**MODIFICATION REQUEST:
CBD and South East Light Rail (MOD 6)**

***Amendment to Condition B47 – Tree
pruning of two trees at the corner of
Alison and Darley Roads***

Environmental Assessment Report
Section 115ZI(2) of the
Environmental Planning and Assessment Act 1979

February 2017

Figure 1 – Location of the two mature trees on the corner of Alison and Darley Road shown in red.

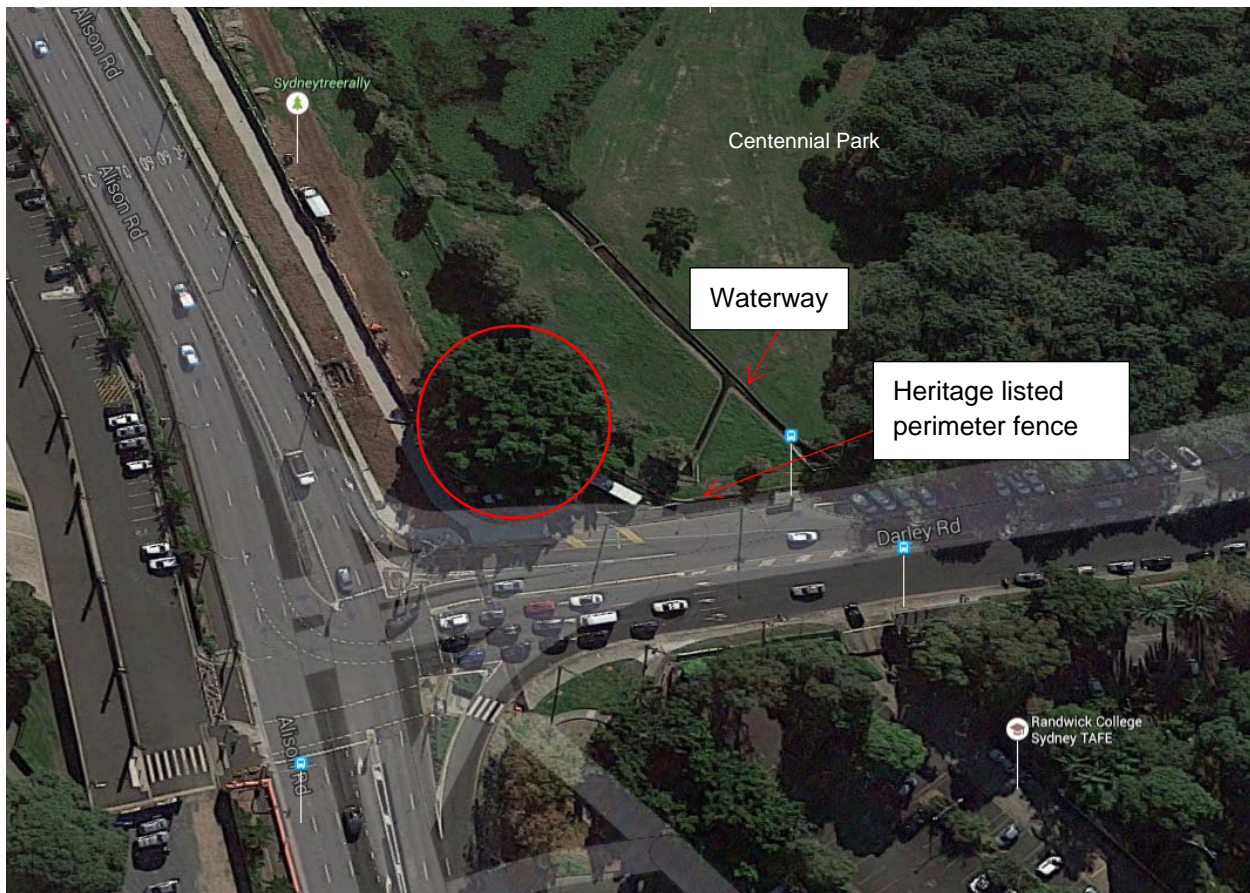
CPMPT considers the two trees to be fundamental to the landscape of Centennial Park and have State and potential National heritage value. CPMPT also disputed that the amount of proposed crown trimming would be restricted to 10% or less for each tree, and considers the tree would be at risk of failing if pruning were to proceed. CPMPT stated its preference for Option 3 of the Modification Report, which would avoid any pruning of the trees.

Council has advised that the pruning of 10% of the crown cover and root trimming of each tree would not adversely affect the health of the trees and is consistent with Council's tree preservation policy. However, it objects to the Proponent's proposed changes to Condition B47 which it considers provides insufficient protection from impact beyond the 10% tree crown proposed for removal. Council's concern is that the proposed modification may allow additional and subsequent tree work/removal without statutory approval.

The Department also agrees with the concerns raised by Council, which considers that the proposed wording of a modified Condition B47 may allow subsequent tree pruning and/or removal beyond the original 10% upper limit without statutory approval. To address this the Department has recommended removing the reference to the two trees in Condition B47 and inserting an additional condition permitting the initial pruning. This will ensure the long term protection of the trees when maintenance pruning during construction. This addresses Council's concerns with the possible future additional pruning beyond that sought in the modification.

Figure 5 – Proposed layout of Option two where the shared path runs adjacent to the track (not to scale).

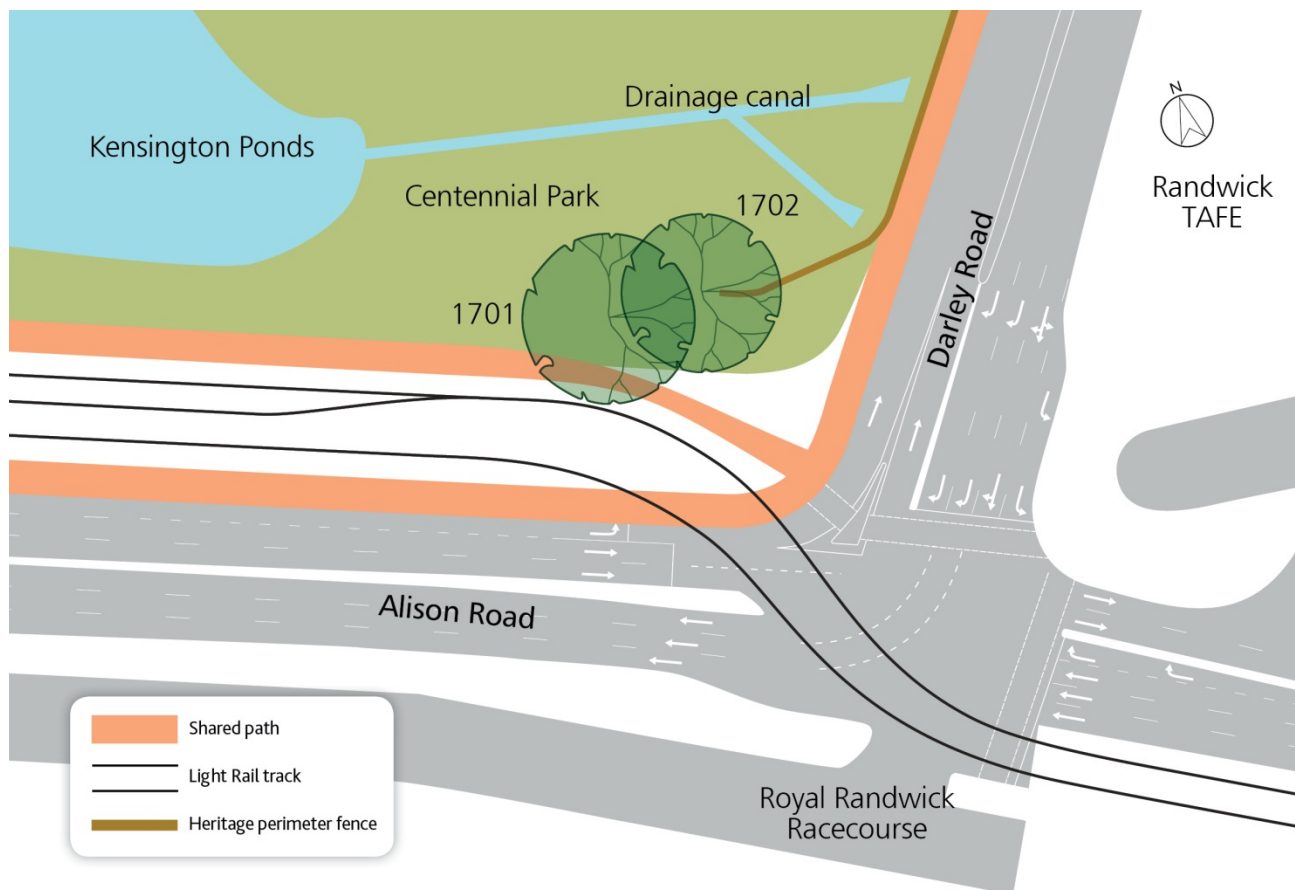
Option 2 (**Figure 3**) was selected by the Proponent as the preferred option as it does not affect operational requirements, traffic phasing or road geometry and would result in minimal visual and heritage impacts over those already assessed and approved. This option would result in the trimming/pruning of no more than 10% of the trees' canopy and root zones, which is consistent with Council's tree preservation policy and recommended by the project's Independent Arborist. This recommendation is based on an arboricultural impact assessment that addresses amongst other matters the condition of individual trees and the tolerance of individual species to disturbance. The trees will remain viable and stable and the Department does not consider the extent of pruning will have a detrimental impact on the long term health of the trees. Accordingly, their associated values, including their contribution to the heritage value of the Centennial Parklands, will be retained.

The Department considers that the Proponent's preferred option is supportable. While Option 2 would impact on the tree canopies, it is considered the best option for minimising construction and operational program impacts as well as to the performance of the Alison and Darley Road intersection. Notwithstanding, the Department considers restrictions are necessary to ensure the long term protection of the trees and has therefore recommended a modified condition that limits the pruning of the trees to a maximum of three metres clearance to the Light Rail overhead wires, and that pruning of the trees must:

- satisfy the requirements of *AS4373 (2007) Pruning of Amenity Trees*;
- be restricted to the minimum amount necessary and no more than 10 per cent of the pre-construction extent of the overhead canopy of each tree;
- not include root pruning of the structural root zone of each tree;
- be supervised by an Arborist; and
- be undertaken in conjunction with management and mitigation measures before, during and after pruning as recommended by the Independent Arborist and included in the Tree Report required by Condition B48.

Figure 6 – Proposed layout of Option three where the track takes a sharper turn to cross Alison Road (not to scale).

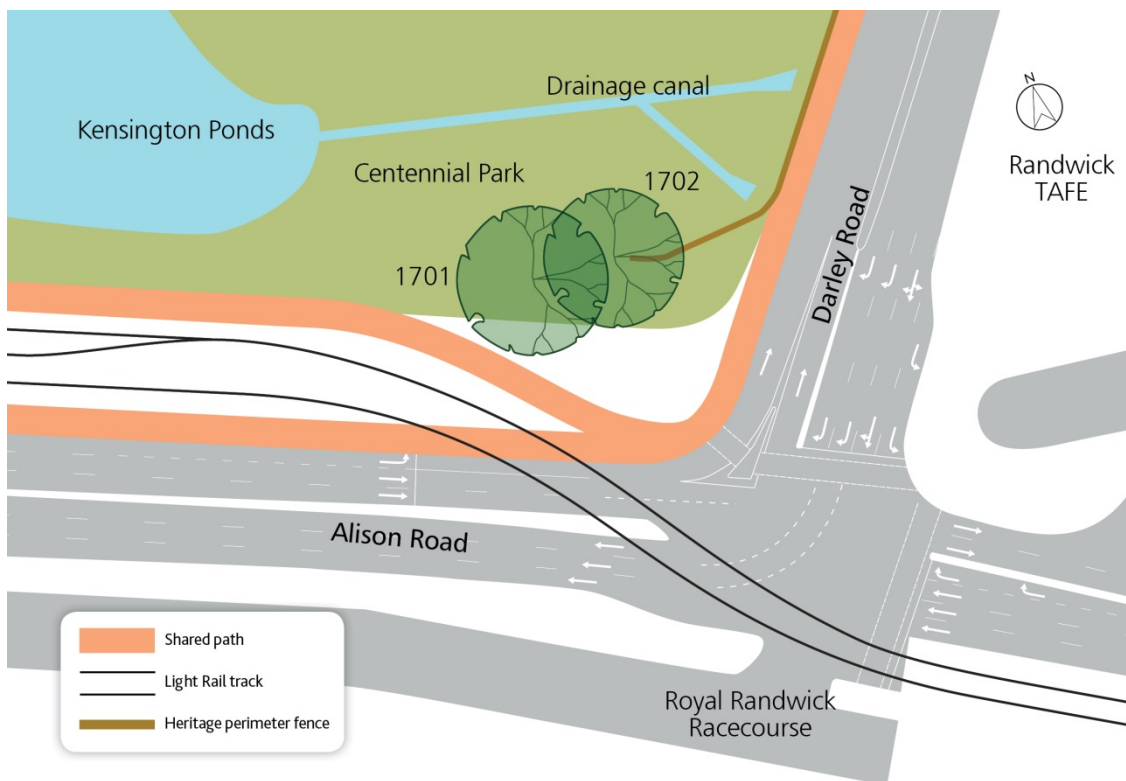
CPMPT indicated its preference for Option 3 (**Figure 4**), which would shift the alignment of the rail track and shared cycle/pedestrian path six metres away from the tree canopy, largely avoiding the requirement for tree and root pruning. While avoiding impacts on the trees, the Proponent determined that this option would have greater impacts on other constraints compared with the other alignment options. Key impacts include disruption to Light Rail construction and operation, and traffic flow through the Alison and Darley Road intersection. Spatial constraints identified include:

Roads and Maritime Services (RMS) provided a submission that further quantified the traffic and safety constraints at this intersection. RMS found that the increase in the length of the Alison and Darley Road intersection, by up to 25 metres for Option 3, would cause further deterioration of the intersection's performance. RMS consider that the additional setback distance required to accommodate the changes would create further operational delays, increases in queuing lengths and congestion. Option 3 was also found to potentially increase the risks to pedestrians crossing the Darley Road slip lane as sight lines for pedestrians and motorists would be affected.
